STAFF REPORT

MEADOW SPRINGS PERFORMANCE BASED CLUSTER PRELIMINARY PLAT

TO: Kittitas County Hearing Examiner
FROM: Kittitas County Community Development Services Staff
RE: Meadow Springs Preliminary Plat (LP-07-00015)
DATE: January 10, 2013

COVER SHEET
OF
MEADOW SPRINGS
A PORTION OF SECTIONS 01 AND 12, TOWNSHIP 19 N., RANGE 14 E., W.M.
KITITAS COUNTY, WASHINGTON

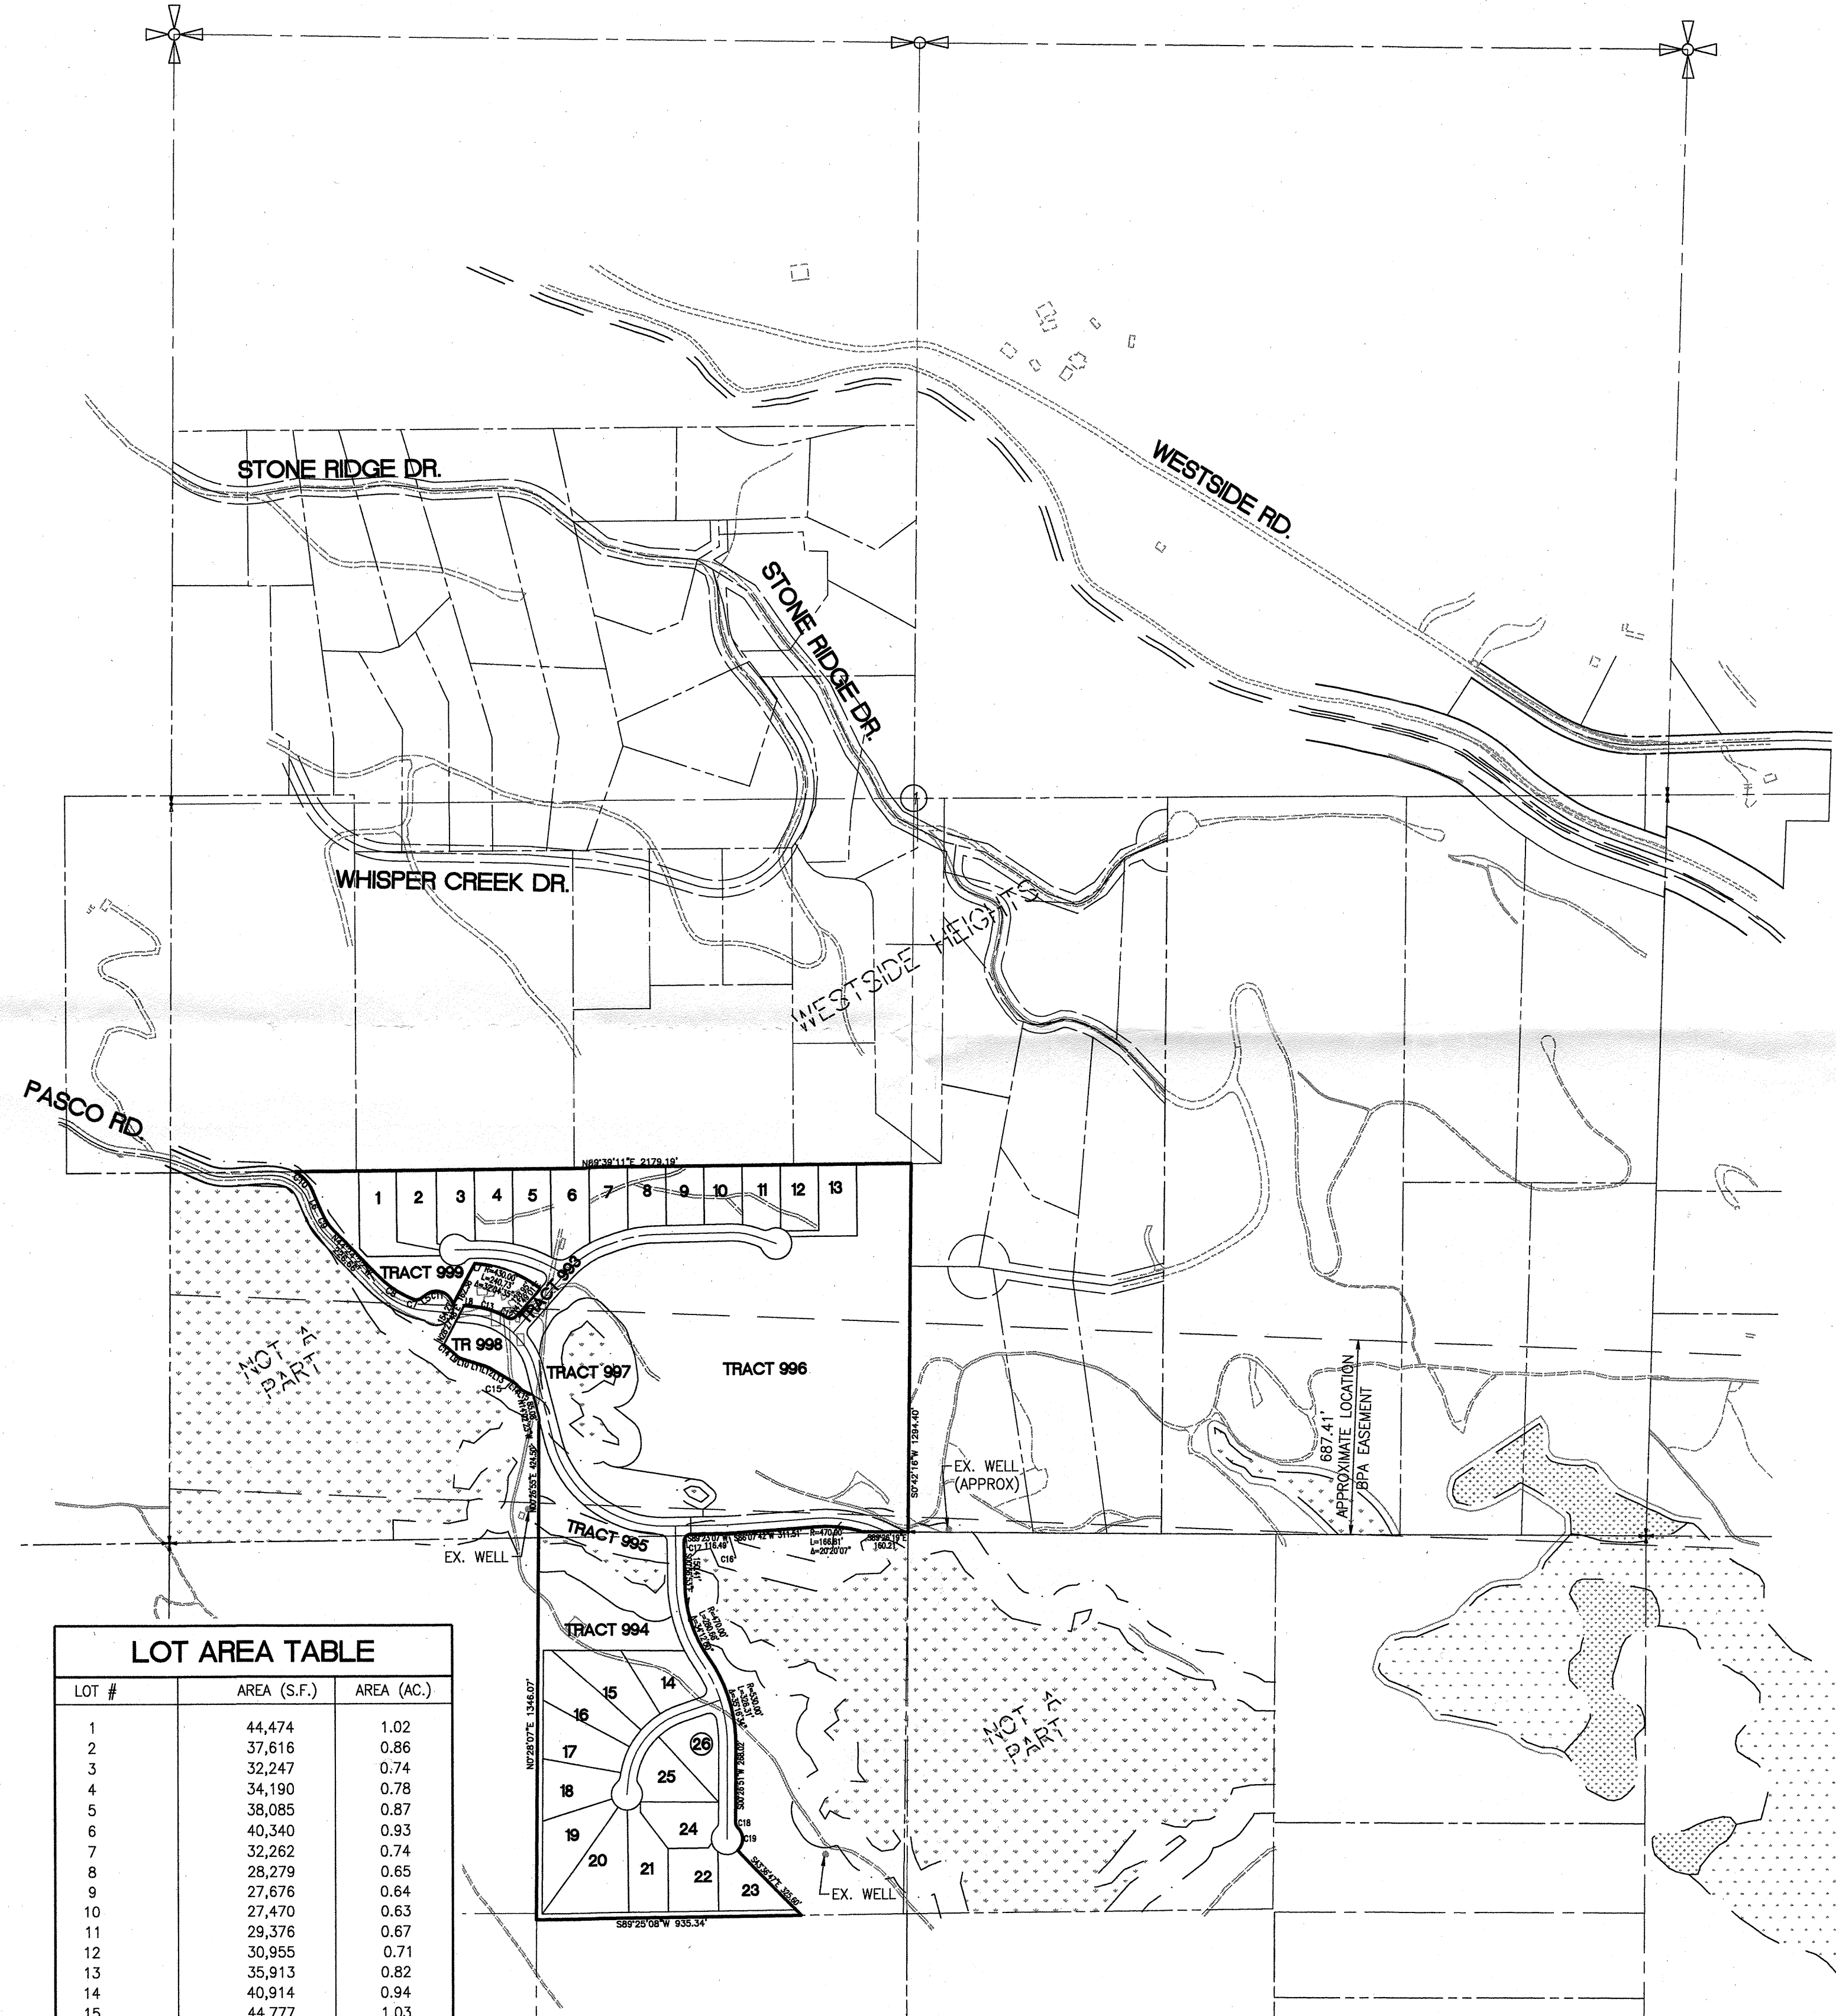
This proposal is not consistent with the Kittitas County Subdivision Code for Preliminary Plats. The page size is too large. KCC 16.12 requires page sizes to be 18 x 24 inches, and the submitted pages are 24 x 36 inches.

- a. The final plat shall be drawn on polyester film in a neat and legible manner.
- b. The final plat shall be drawn to such a scale as to make a sheet eighteen inches by twenty-four inches. Should this size sheet unduly congest the drawing, the plat may be submitted on two or more sheets of the above dimensions. The perimeter of the subdivision shall be depicted with heavier lines than appear elsewhere on the plat. A marginal line shall be drawn completely around each sheet, leaving an entirely blank margin of one inch on the sides. The scale shall be one (1) inch equals two hundred (200) feet, or greater, unless otherwise approved by the director.
